Lead Local Flood Authority

Date 5th June 2026

RE: WA/18/26/PL - Land off Arundel Road Fontwell

This is a full application for the erection of 64 residential dwellings with access off Arundel Road, together with associated parking, open space, play space, landscaping, drainage and infrastructure.

Drainage Plans and Calculations

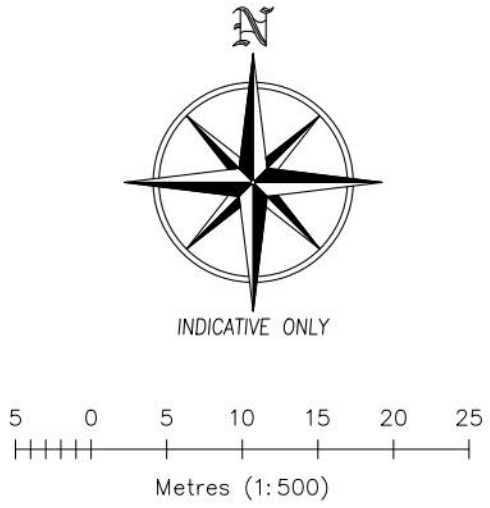
While water butts are mentioned in 1.3.4 for rainwater harvesting, these are not included in the Drainage Strategy Plan. To ensure these are included during construction, we would recommend a note or the location of the water butts is added.

It has been demonstrated that infiltration is not a viable method of draining the site, as high groundwater levels mean a 1m freeboard cannot be provided between the base of the basin and the highest groundwater level (as stated in National Standards for SuDS). As there are no ordinary watercourses nearby, it is proposed to discharge surface water at a restricted rate into WSCC highways drainage, as previously discussed with highways in January 2025. In those emails, the applicant proposed replacing a poor condition 150mm diameter highway drainage pipe with a 225mm diameter pipe. This is not included in the Drainage Strategy Plan.

While infiltration is not being used to drain the site, there are several instances where the drainage strategy implies infiltration is still being used. For example, paragraphs 1.3.23 and 1.3.34 and the Contributing Areas Plan and Drainage Strategy Plan all still mention infiltration or infiltration basin. This does not accurately reflect how the site is proposed to drain. There may be other instances where this is an issue. It is also important that this is

While a swale is mentioned in para 1.3.20 to 1.3.21, it is not included in the Drainage Strategy Plan or calculations.

In the Contributing Areas Plan, the footprint of the attenuation basin is not included, which conflicts with the National Standards for SuDS. We request this is updated, with the Drainage Strategy Plan and corresponding hydraulic calculations amended where necessary.

It is unclear whether the design of the attenuation basin has considered the high groundwater levels. We request a cross section of the basin and porous paving, to ensure groundwater is considered in the design of SuDS features.

It is unclear whether freeboard from the 1 in 100 year plus climate change event has been included in the basin design.

There appears to be some conflicts between the current Drainage Plan and the landscaping plans with regards to proposed tree planting locations and open SuDS features.

A minimum 3m easement for the attenuation basin is required, for maintenance access.
